OXFORDSHIRE COUNTY COUNCIL'S RESPONSE TO CONSULTATION ON THE FOLLOWING DEVELOPMENT PROPOSAL

Application no: 14/02121/OUT

Proposal: Development to provide up to 1,700 residential dwellings (Class C3), a retirement village (Class C2), flexible commercial floorspace (Classes A1, A2, A3, A4, A5, B1 and C1), social and community facilities (Class D1), land to accommodate one energy centre and land to accommodate one new primary school (up to 2FE) (Class D1). Such development to include provision of strategic landscape, provision of new vehicular, cycle and pedestrian access routes, infrastructure and other operations (including demolition of farm buildings on Middleton Stoney Road)

Location: Himley Village North West Bicester Middleton Stoney Road Bicester

Primary Road - Type C

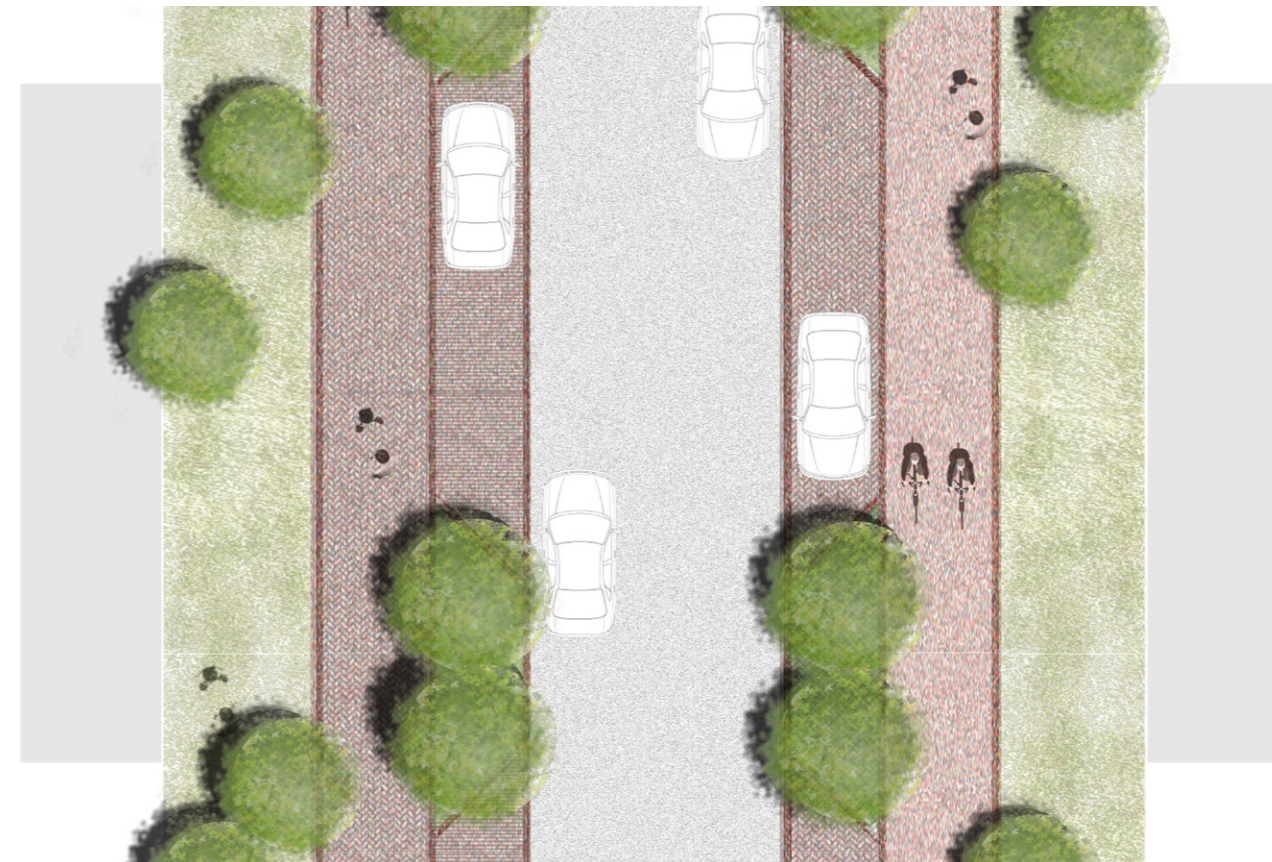
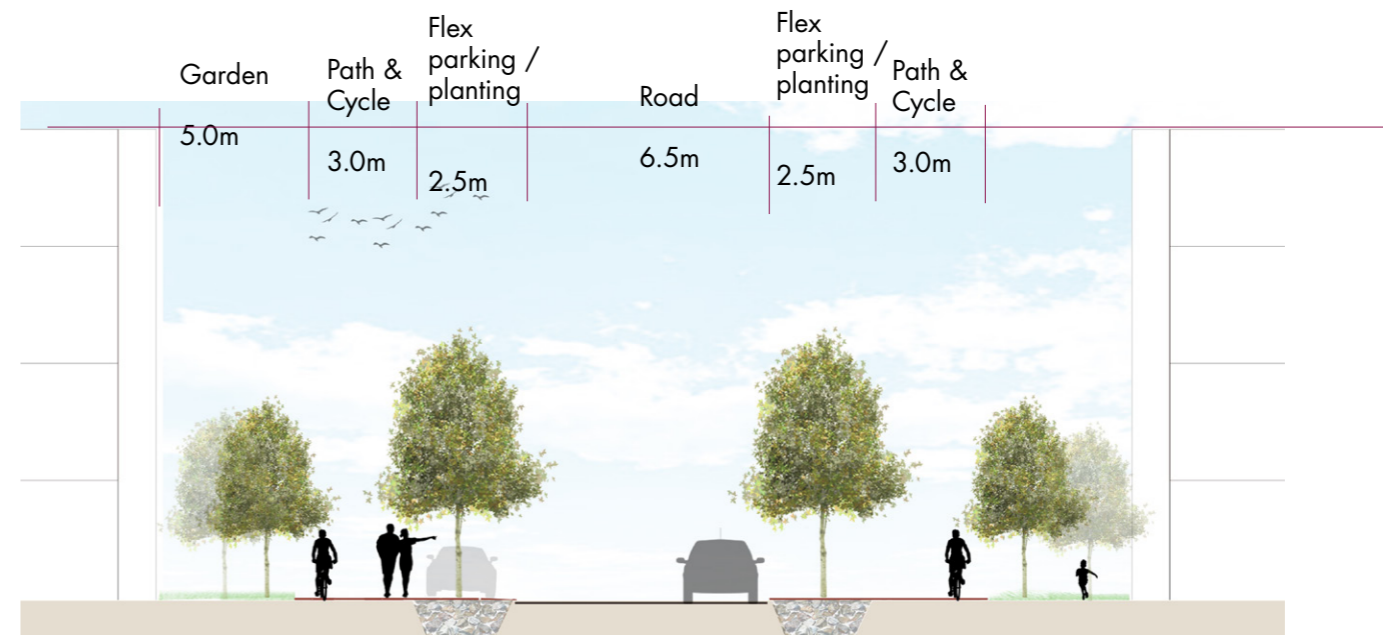
The illustrative layout of the site sets out a grid with an appropriate street hierarchy. A high level of permeability, for those on foot or cycle, is demonstrated. Walking and cycling distances to local shops, schools and public transport links would be within relatively short walking distances via attractive lit and overlooked routes. Bus stops are identified within 400m of every dwelling excepting a handful. Bus services are an essential element of sustainable merits of the site and it is imperative they are not delayed through the site. Appropriate consideration to the movement of buses must be included within the detailed design of the street and junction layouts.

Figure 7.2 Primary and Secondary Connections from NW Bicester

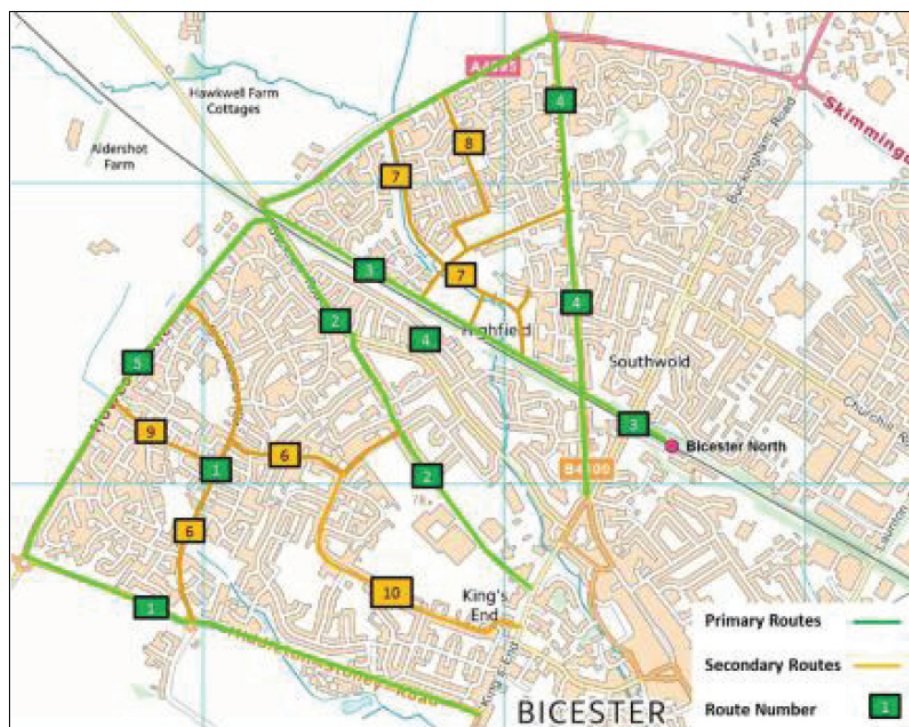
Good to see use made of the extensive cycle audit that was undertaken as part of the masterplan work. Primary routes along Middleton Stoney Road and the route past the Community College will be fundamental (primary routes 1 and 2) and the secondary route along Shakespeare Drive (secondary route 9 and 6) is also important. Pleased to see it acknowledged that these will form part of the section 106 negotiations, although the primary routes will need to be directly delivered by the developments to the south of the railway to mitigate the impact and provide the mode share opportunities that are fundamental to these sites.

Figure 7.3 Vehicular Access strategy

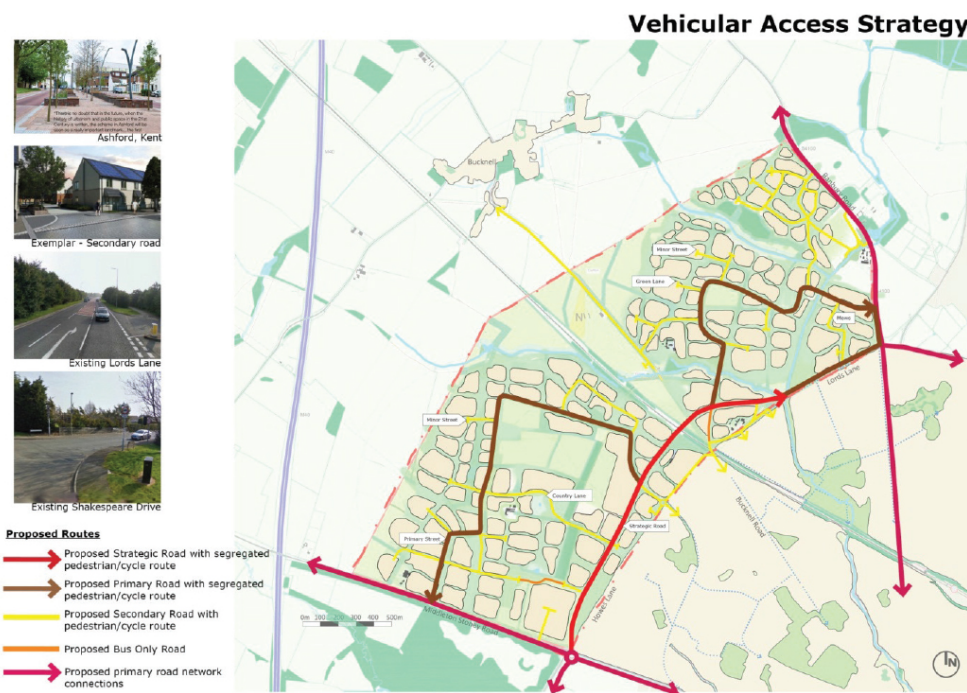
P62 – access off of Middleton Stoney Road – this is mostly a technical engineering matter, but from a strategy point of view it is important to lessen the impact on Middleton Stoney Road by minimising accesses as this will remain an important artery into the town for surrounding villages.
